**To:** FILE  
**From:** Caitlin Cameron  
**Subject:** Application ID: 2016-021  
**Date:** 2/19/2016

**Comments Submitted by: Caitlin Cameron/Planning on 2/19/2016**

Re: 169 Newbury St – Luminato Condominiums

5 CATCHBASIN #2 SECTION (II-2)
NOT TO SCALE

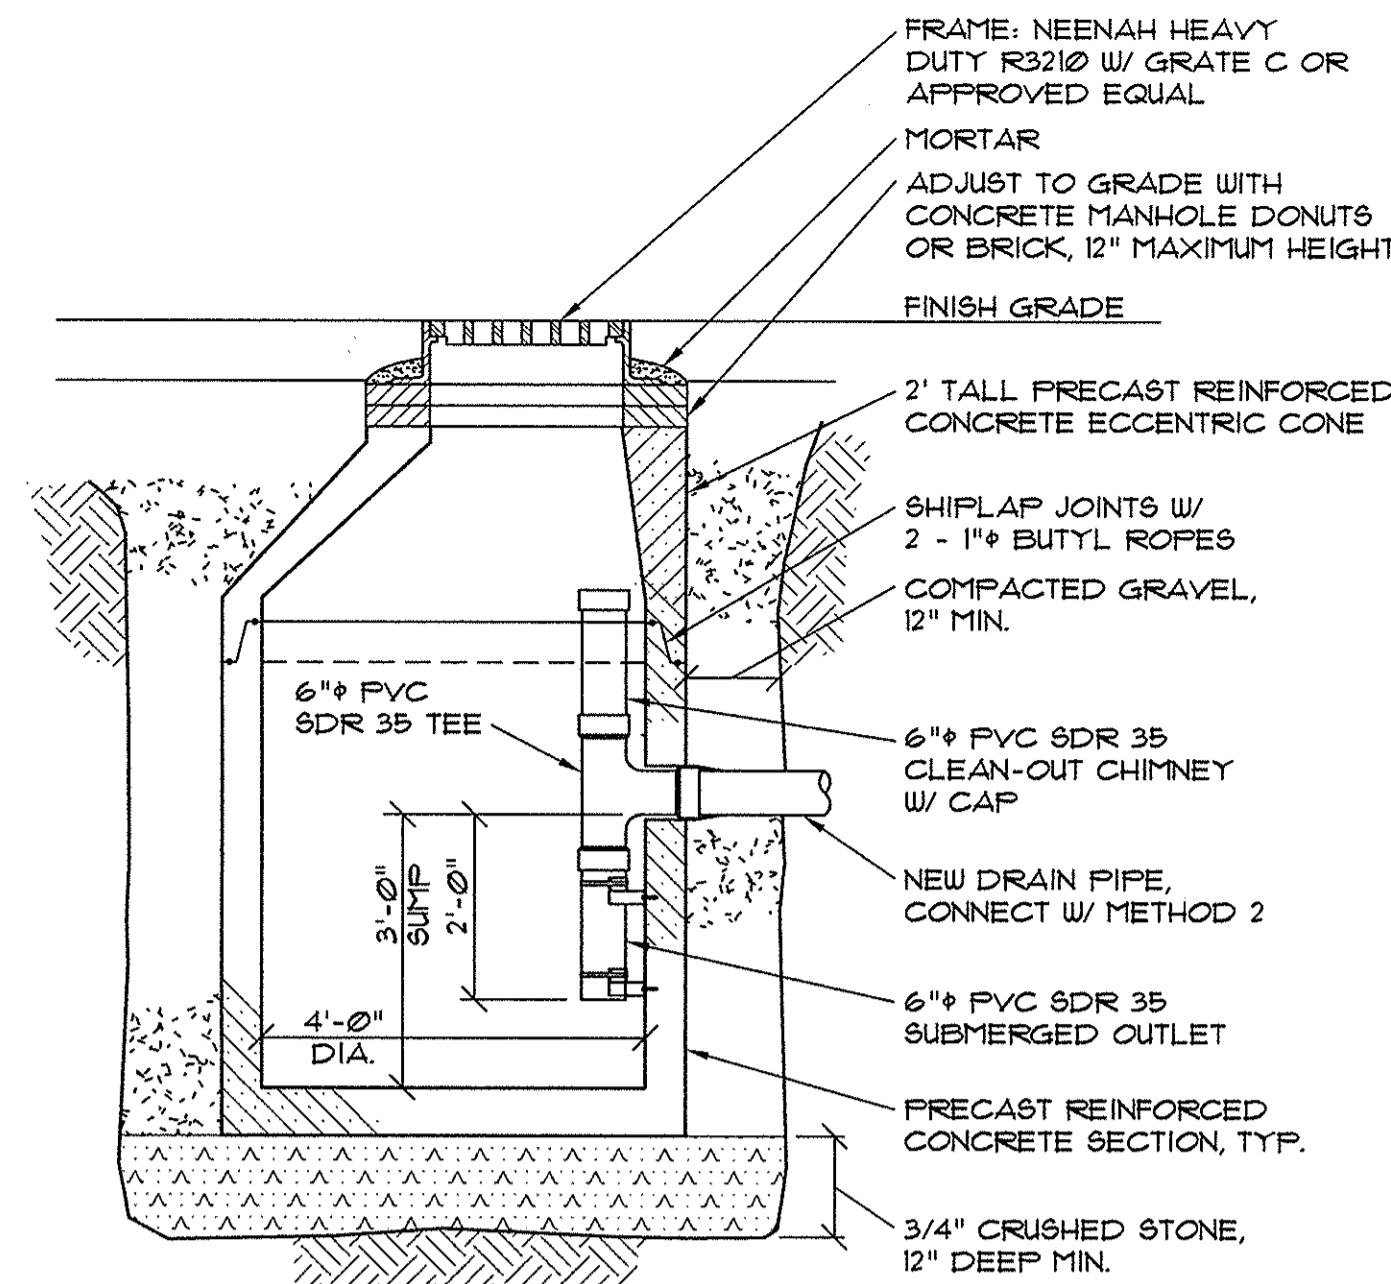
3. A temporary construction easement will be required from the City to construct this project due to the encroachment of Franklin St.
  4. It is understood that all roof and site drainage will be directed to proposed catchbasin #2 in Newbury St. or to the ground and not the sanitary sewer system. Please confirm that this is the case. Please note that N-12 is not permitted within the street right of way. Please consult Chapter Two of the City's Technical Manual for acceptable pipe material options.

7. An oil/grit separator will be required within the parking garage on both levels. Modifying the proposed catchbasin to include a three foot sump and down turned 90 degree bend to allow for one foot of oil capture is acceptable. Please show detail and indicate oil/grit locations on plans. Please keep the sanitary lateral connections downstream of the oil/grit separators and change the designation of the line from SD leading to the City's sanitary sewer.

8 TYPICAL BACKFLOW PREVENTOR DETAIL
NOT TO SCALE

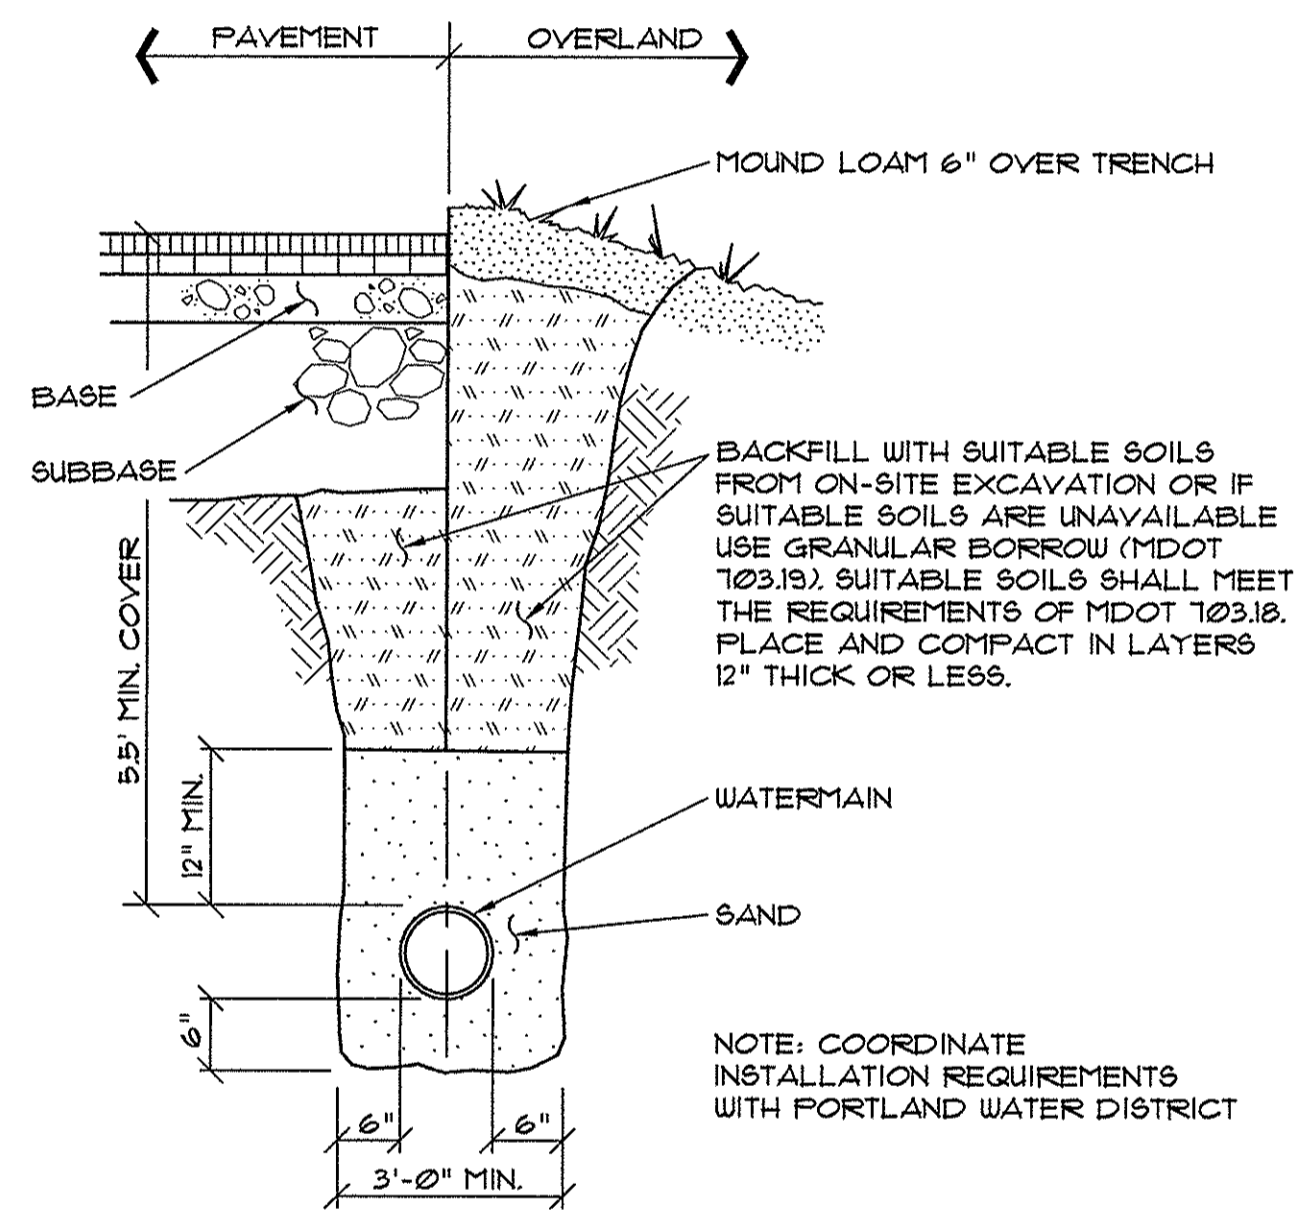
8. Since the sewer systems are separated, a backflow preventer on the sanitary lateral is not required by the city. If the applicant wishes to install one, please place the backflow preventer on the applicant's property.

**5 BITUMINOUS DRIVEWAY APRON (I-13)**  
NOT TO SCALE

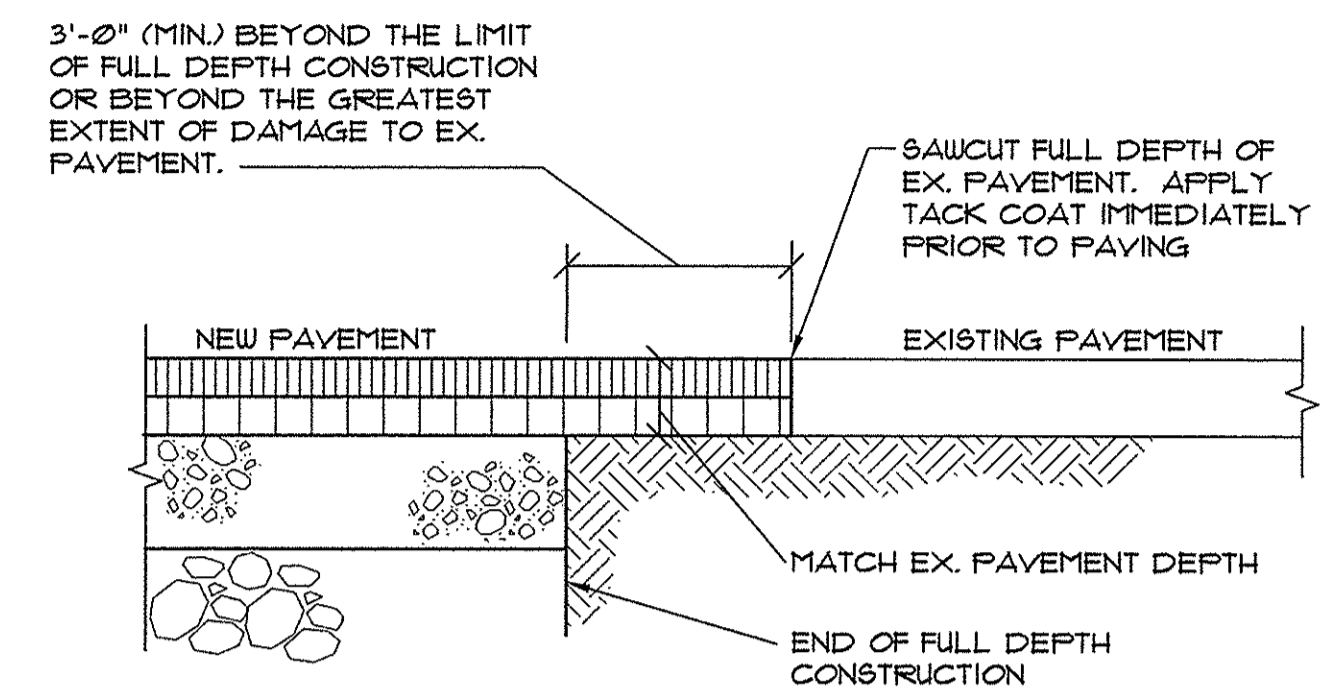
5. The applicant is showing a brick driveway apron within the street right of way on Newbury St. This is a deviation of the City's material policy which calls for an asphalt apron. This department is supportive of a waiver request however the applicant will need Council approval and signoff on maintenance agreement of the drive apron within the road right of way.
